CITY OF ALBUQUERQUE

Re: Westside Skate Park Phase 1, 6900 Gonzales Road SW, Site Development Plan

Engineer's Stamp dated 8-08-05 (L10-D13A)

Based upon the information provided in your submittal received 8-08-05, the above referenced plan is approved for Paving Permit and Grading Permit. Upon completion of the project, please provide an Engineer Certification for our files.

CITY OF ALBUQUERQUE DEPARTMENT OF MUNICIPAL DEVELOPMENT	
TITLE: WESTSIDE SKATE PARK - PHASE 1-A GRADING PLAN	
Design Review Committee	City Engineer Approval
City Project No. XXXXX	Sheet 5 of 11

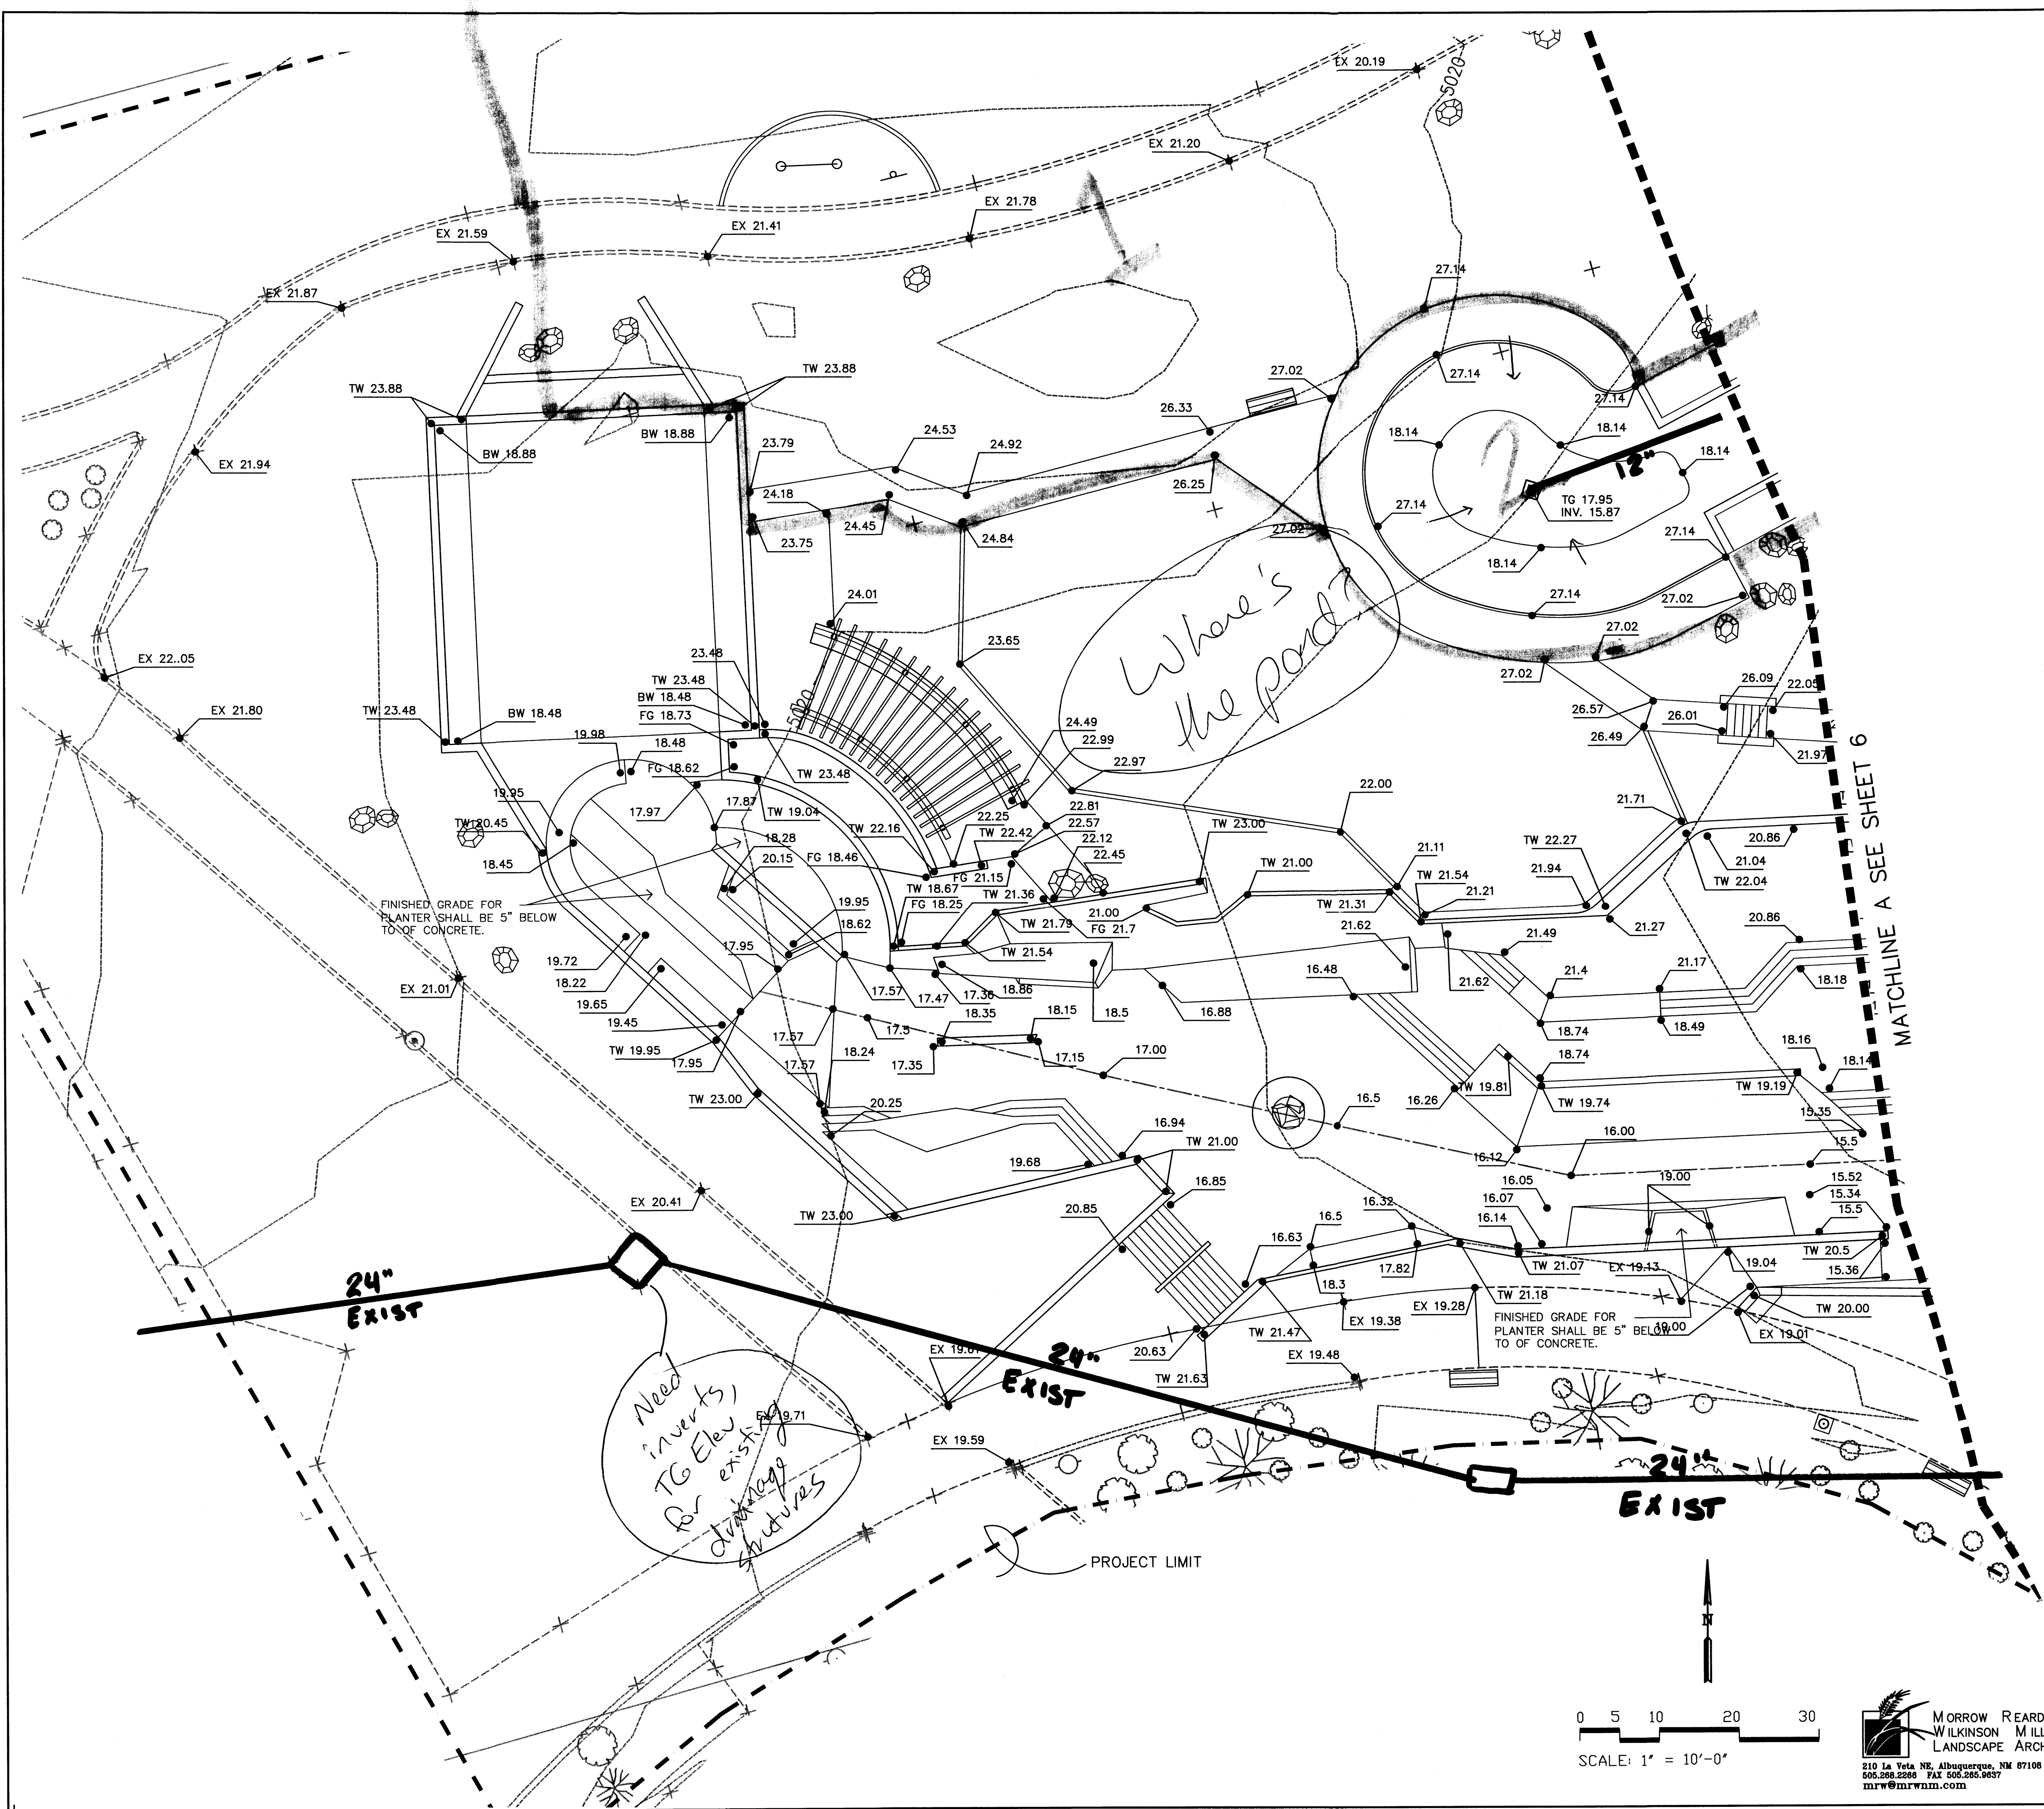
1. The 18" wide spillway must be hardlined.
2. Show the proposed and existing storm drain, along with associated inverts, on the grading plan (sheets 5 and 6).
3. Clearly indicate the ponding area on the grading plan (sheet 6).
